OFFICE BUILDING SHELL
DRB RESUBMITTAL
2022-04-27

PROJECT NO. PR-2019-003021

Application No. SI-2022-00308

Re: Resubmittal for a Major Amendment for Site Development Plan for Building Permit for the Proposed New Construction for Tract 5-A-1, Block C, Louisiana Subdivision at 2440 Louisiana Boulevard NE

SIDEWALK WIDTH WAIVER REQUEST AREA

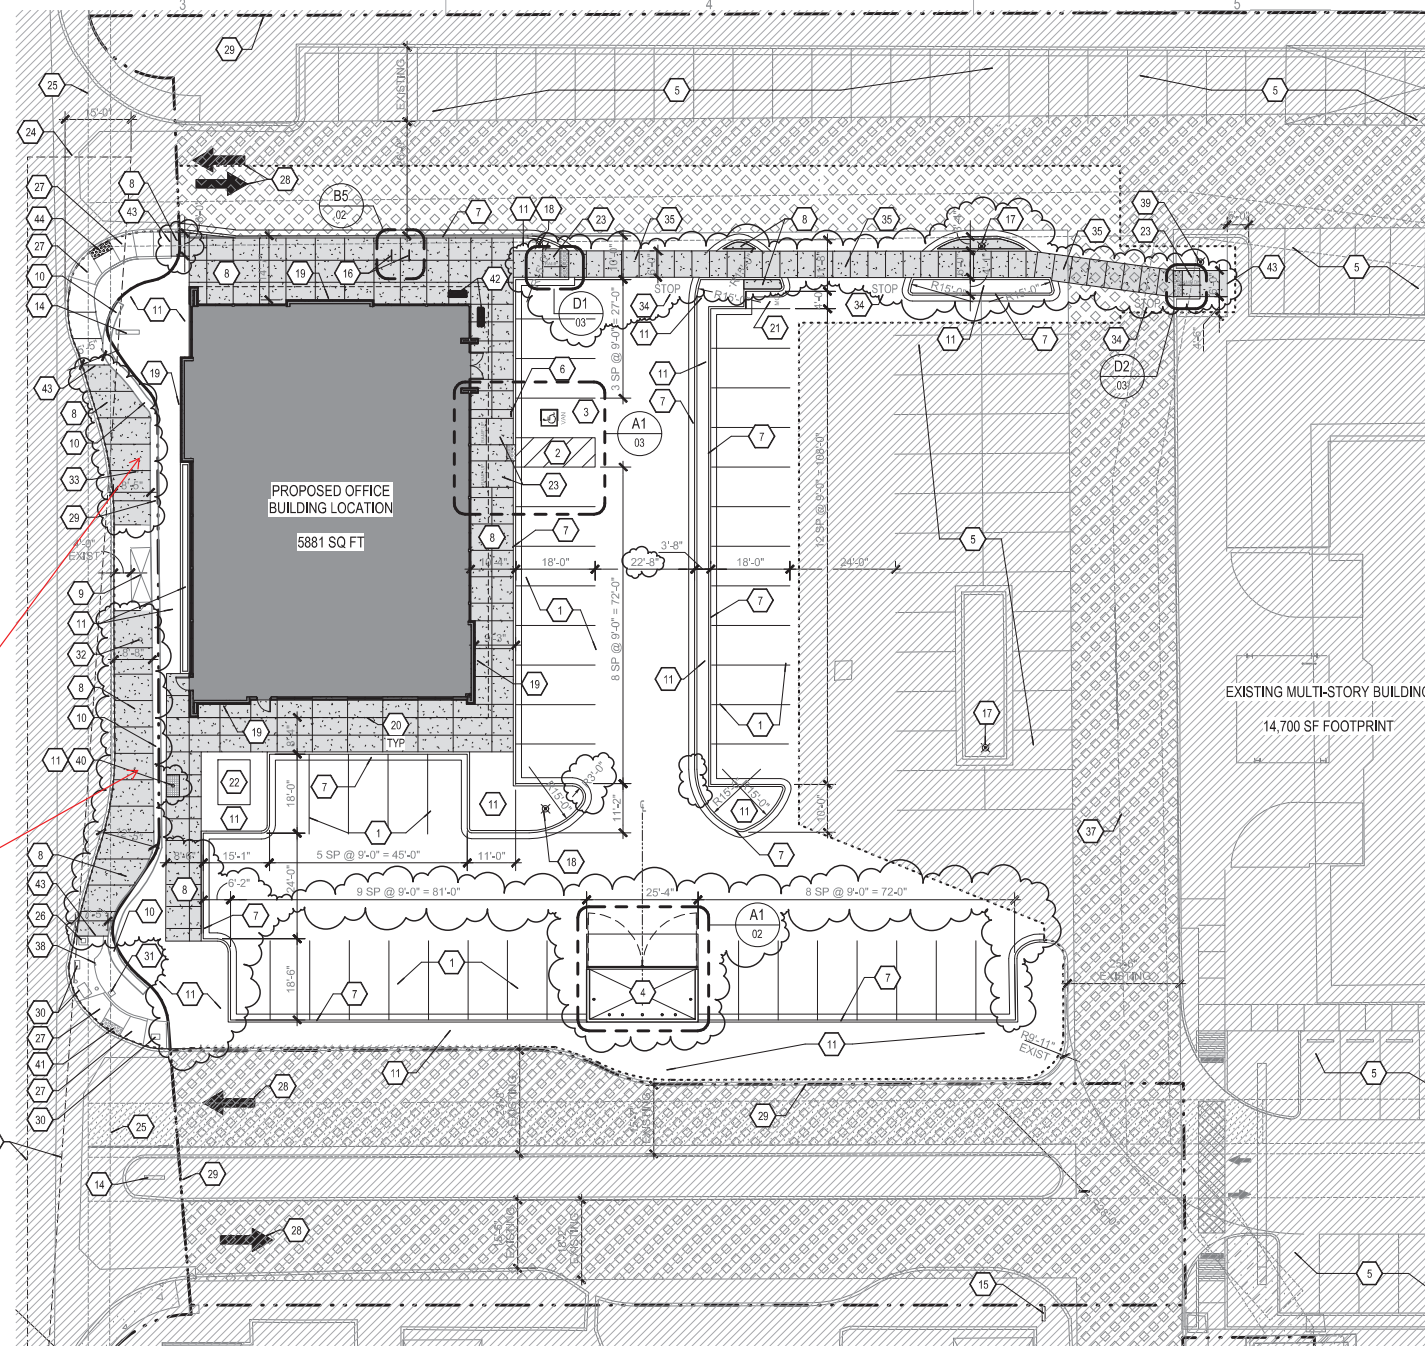
1. There is a sidewalk waiver, but on the Infrastructure List, a 10-foot sidewalk is shown. If needed, use a range to fit what is actually being constructed. Also reference 2430 for the new sidewalk.

5. A Sidewalk Waiver application has been applied for from the requirement to construct a sidewalk along Louisiana (within a Major Transit Corridor inside a center) 10 – 12 feet in width. In their waiver application, the applicant notes that an existing retaining wall and several obstructions prevent widening the sidewalk to meet the requirement. Per staff's analysis, the applicant has justified the waiver.

- a. **Response: The Infrastructure List now shows a sidewalk width range of 8'-10'.**
2. Show Tract Numbers on the site plan that match those referenced within the Shared Access Agreement. The Tract numbers are unclear.
